**SUBMISSION TO THE DEPARTMENT OF PLANNING AND INFRASTRUCTURE ON THE PROPOSED
NORTH WEST RAIL LINK (NWRL)**

Name: Dave Chelms

Application Number: SSI-5100

Figure 6.11 Cheltenham Services Facility light vehicle access and egress

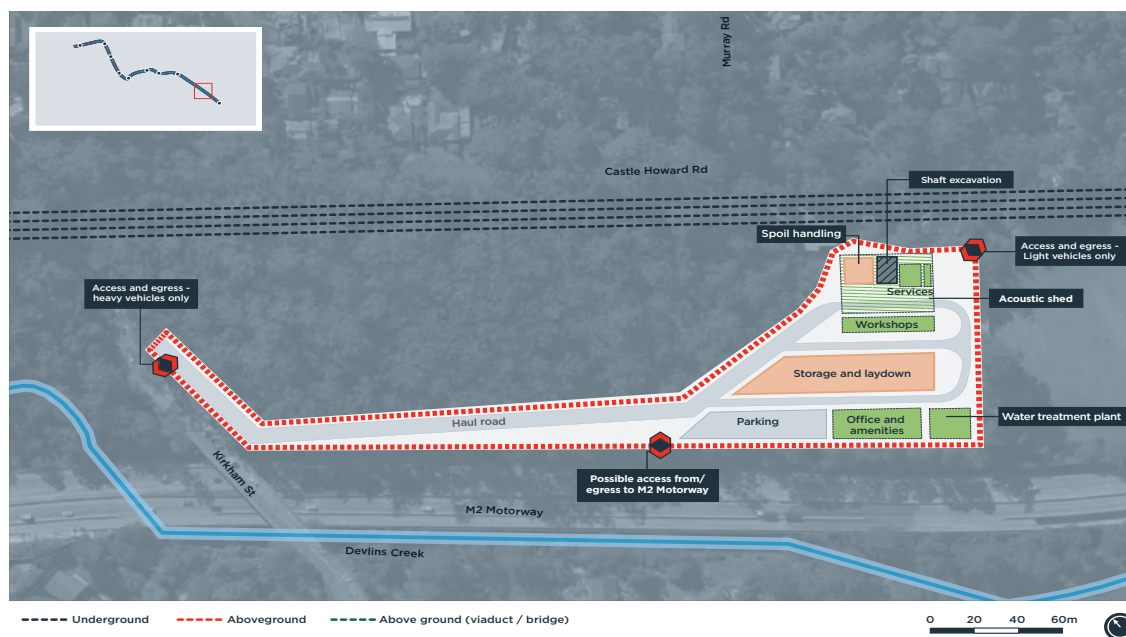
1. The option to construct a new two lane paved road through the Castle Howard Conservation Reserve to Kirkham Street (or Castle Howard Road) near the bridge over the M2 to allow trucks to remove spoil during construction and light vehicle access during operation of the facility will permanently destroy valuable Blackbutt Gully forest.

5. Should the roadway be built, the local streets (Kirkham Street, Castle Howard Road, Murray Farm Road and the bridge over the M2) are narrow, winding and congested and would not be suitable for trucks and, in the event of an emergency, large numbers of emergency vehicles.

6. There are no traffic lights at the corner of Kirkham Street and Beecroft Road. This is a dangerous intersection for traffic and pedestrians and would not be suitable for trucks and emergency vehicles.

I therefore ask that you adopt the alternative option of access to the site for construction and emergency vehicles be via new on and off ramps from the M2 motorway. The current widening and reinstatement of the breakdown lane should allow this access. It is the only practical way to move trucks in and out of the site. In the event of an emergency, many emergency vehicles would need quick access to the site from areas outside Beecroft and Cheltenham as it only has one fire engine.
